CITY OF ALBUQUERQUE

**Re: Cottonwood Mall,
10000 Coors Bypass NW, 87114
Request for Certificate of Occupancy
Transportation Development Final Inspection
Engineer's/Architect's Stamp dated 3-20-18 (B14D004F)
Certification dated 10-1-18**

Based upon the information provided in your submittal received 10-17-18, Transportation Development cannot approve the release of Certificate of Occupancy for the above referenced project.

**C-2**

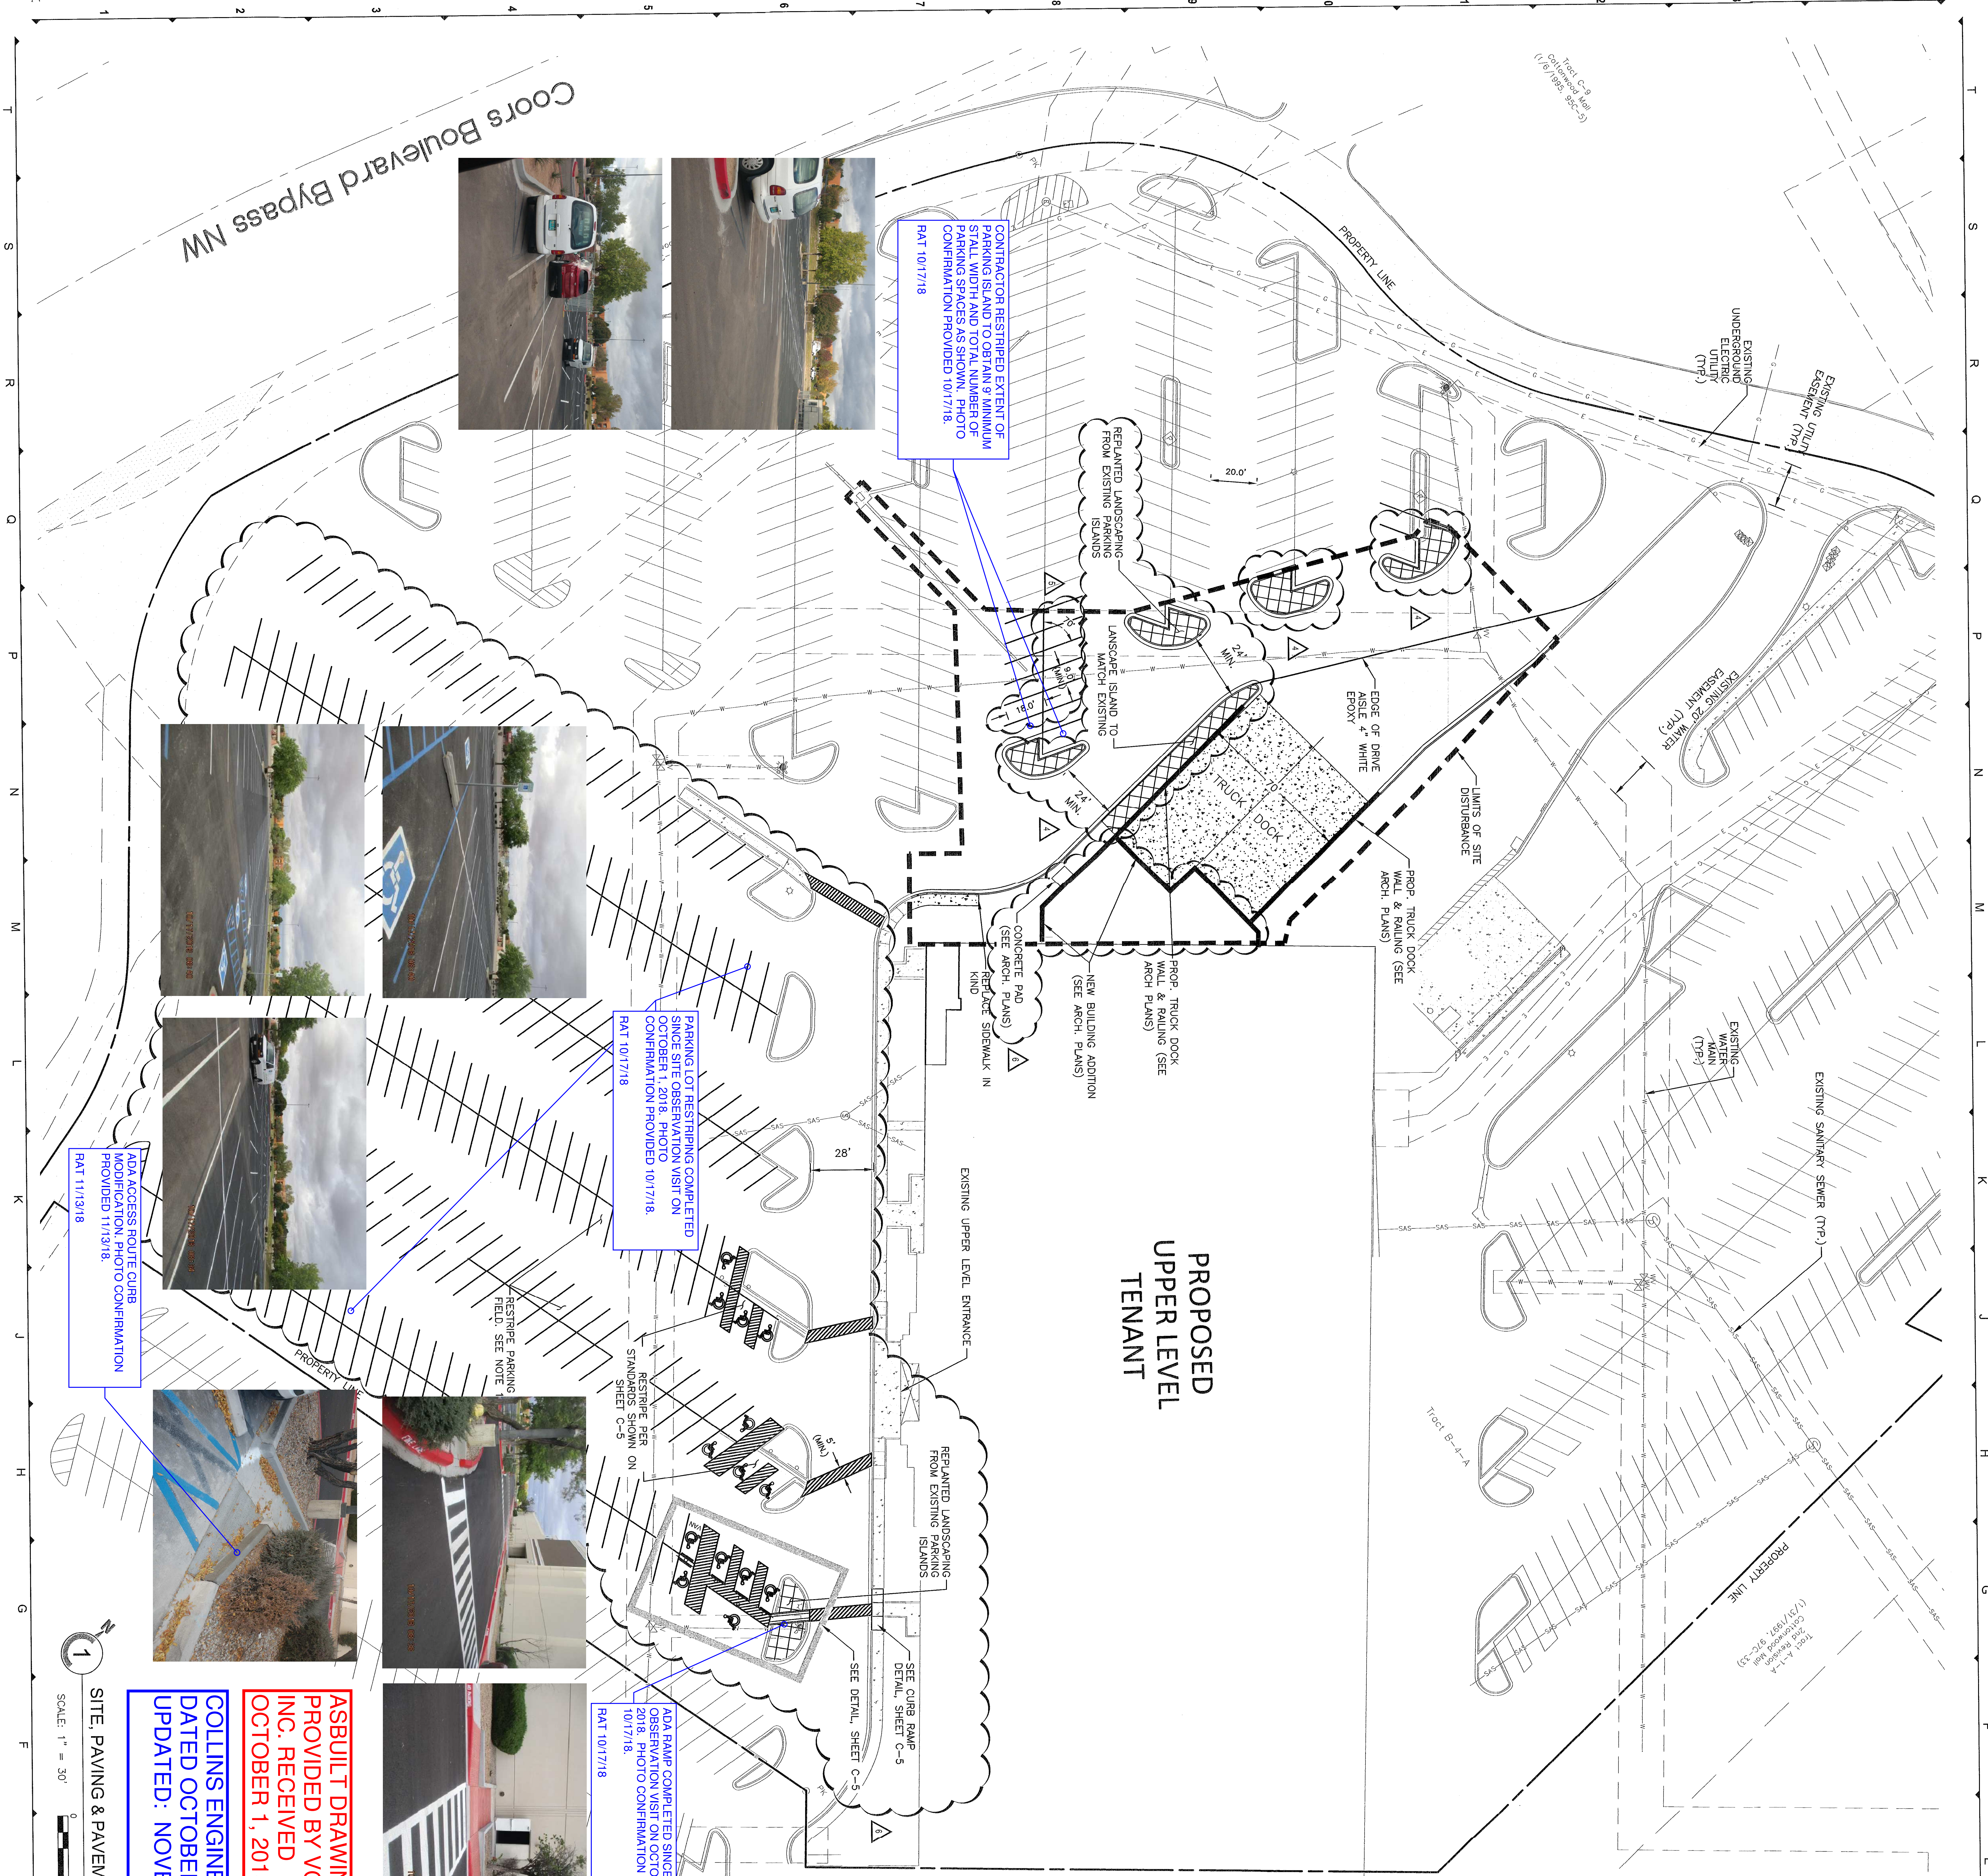
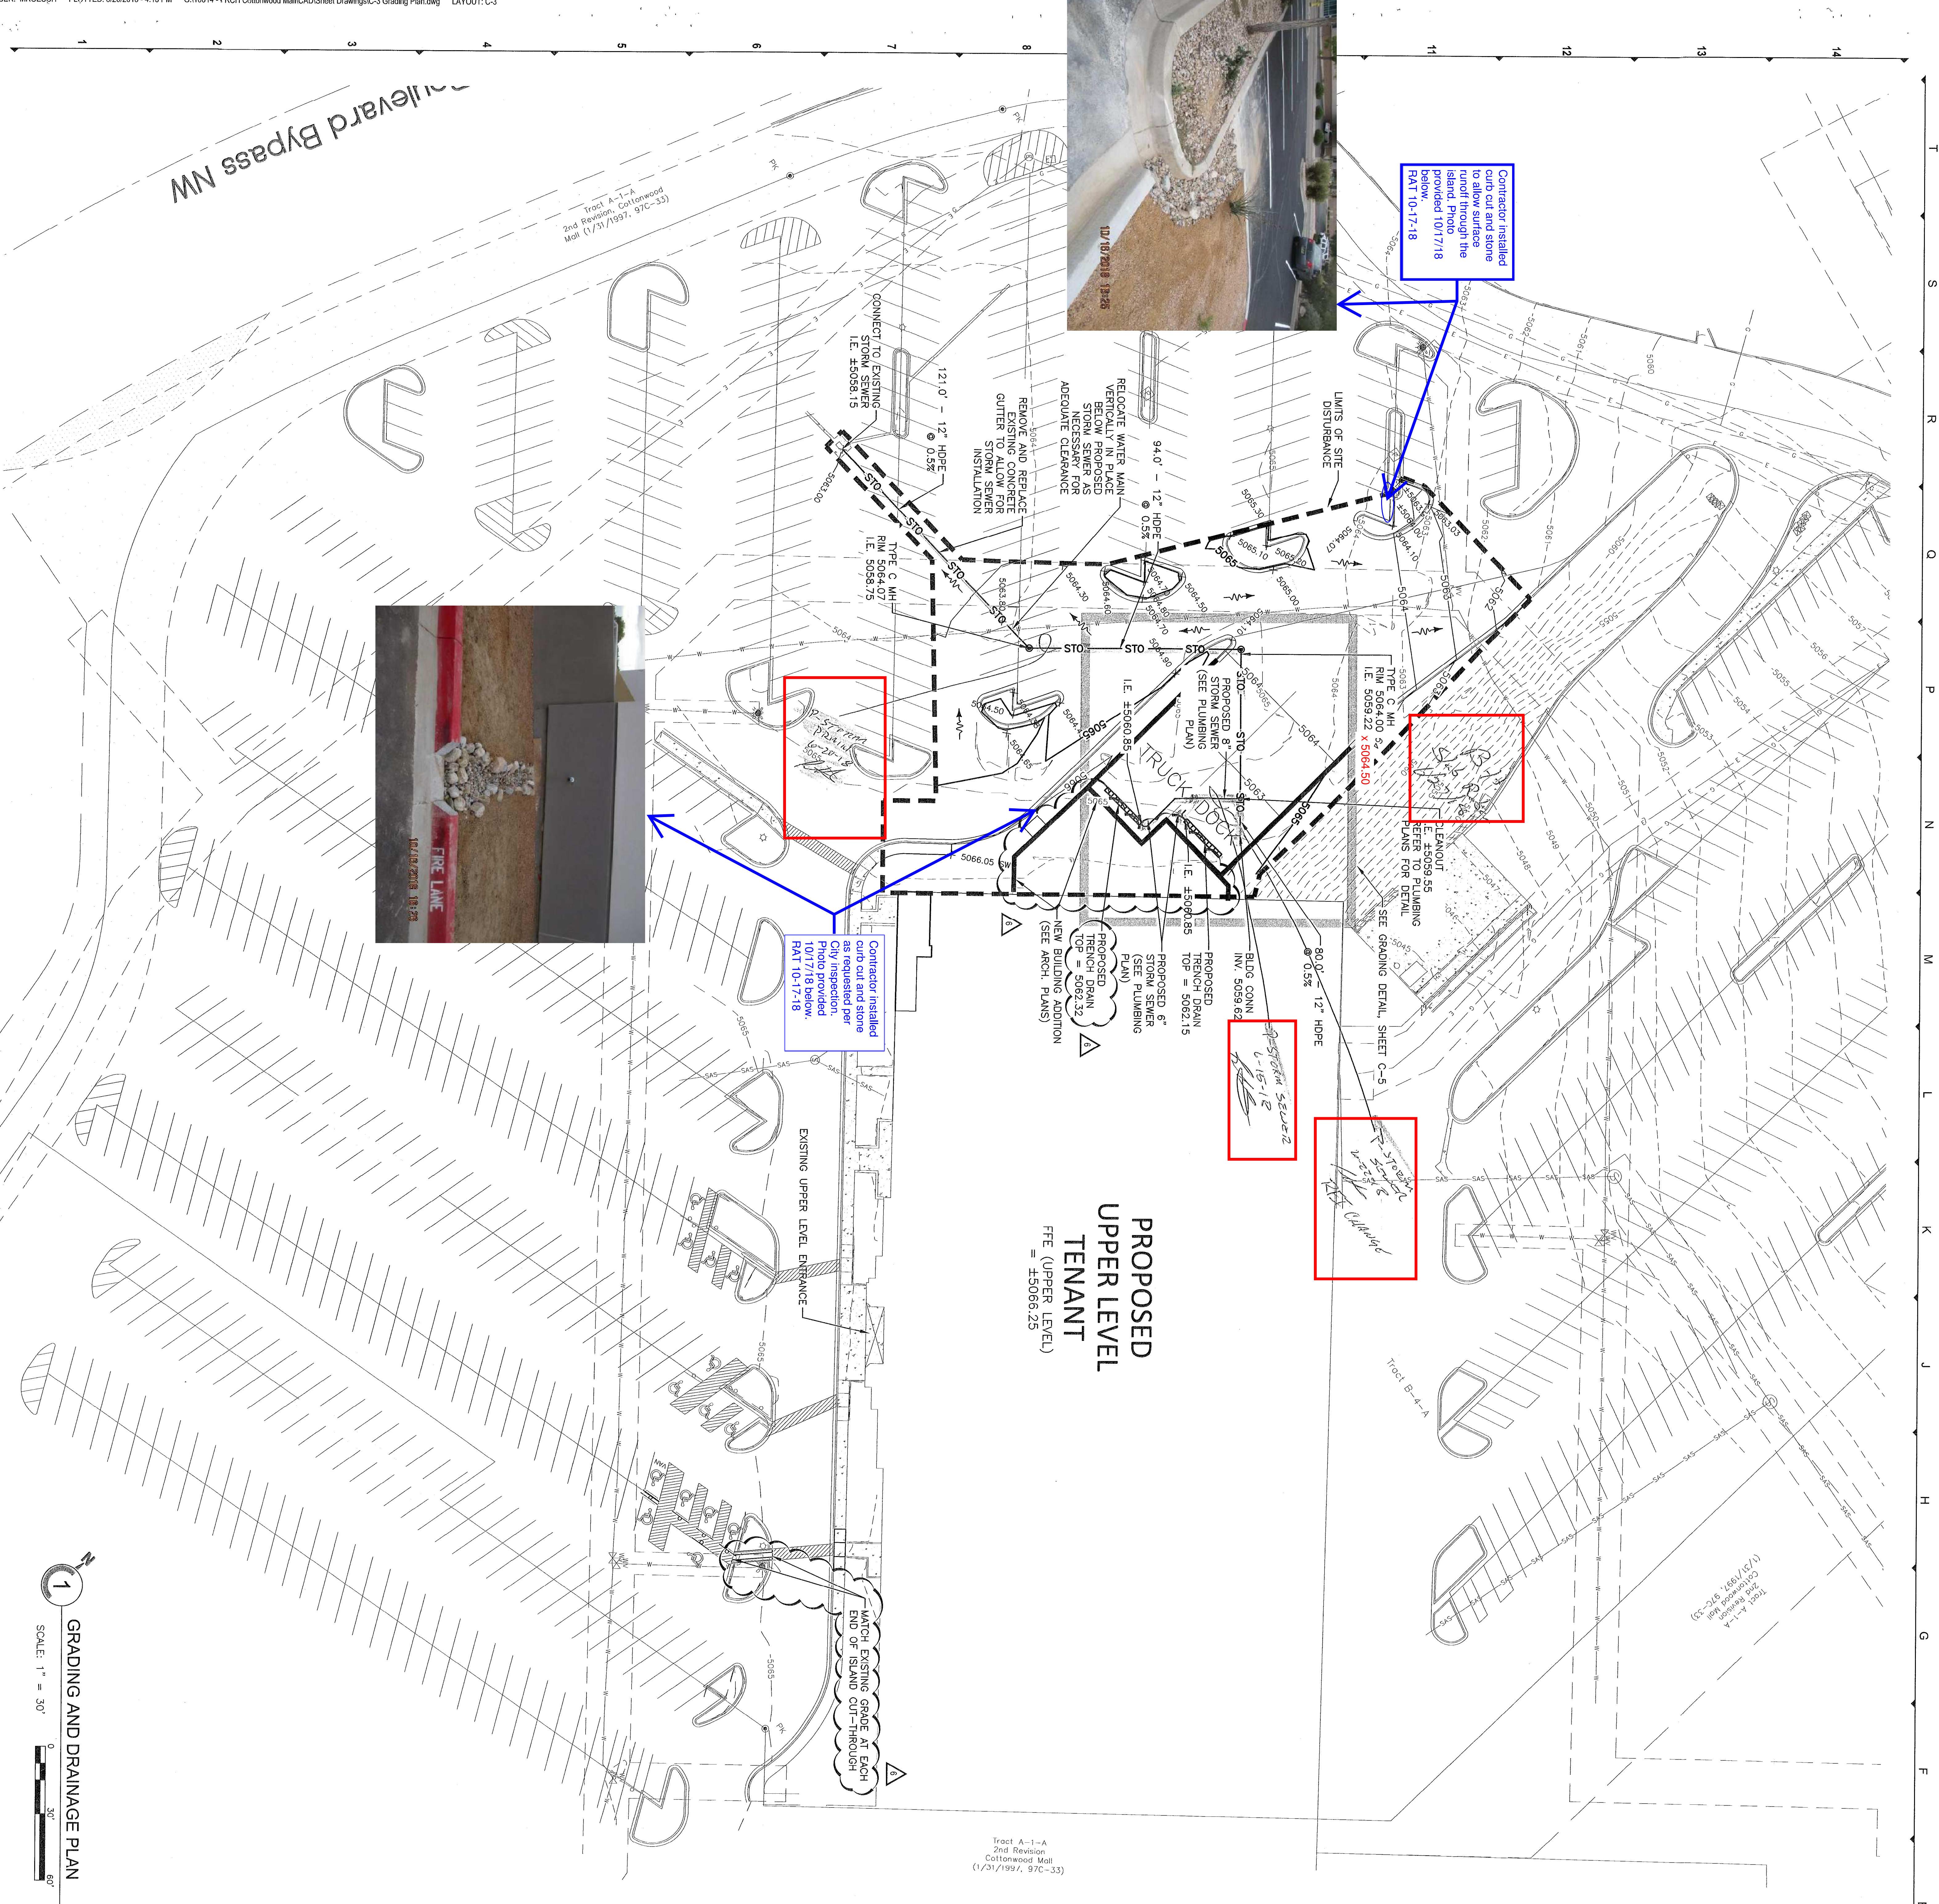
1. 3, ADA parking stalls do not meet ADA dimension requirements, please correct. 18' in length is required. Stalls measured 16' in length. See attached photo.
